## Department's Comments

**FIGURE 4**  
**POTENTIAL MAXIMUM NUMBER OF VEHICLES ON-SITE AT ANY ONE TIME**

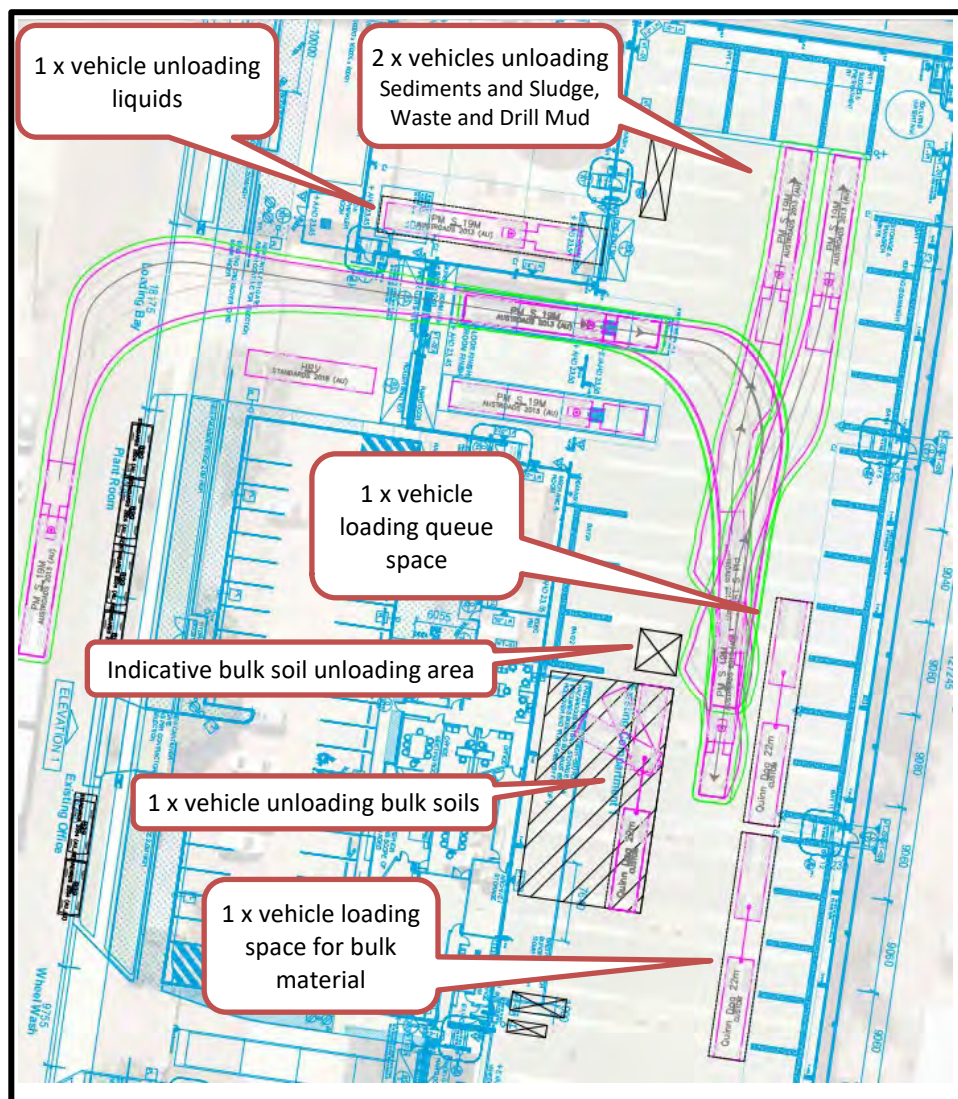
- Provide a queuing plan of the maximum number of heavy vehicles predicted to be on site at any given time. Would there be sufficient length between the weighbridge and the lot boundary for a truck to queue while waiting to enter the weighbridges? If not, provide adequate traffic management measures to ensure the proposal does not cause queuing in the road reserve.
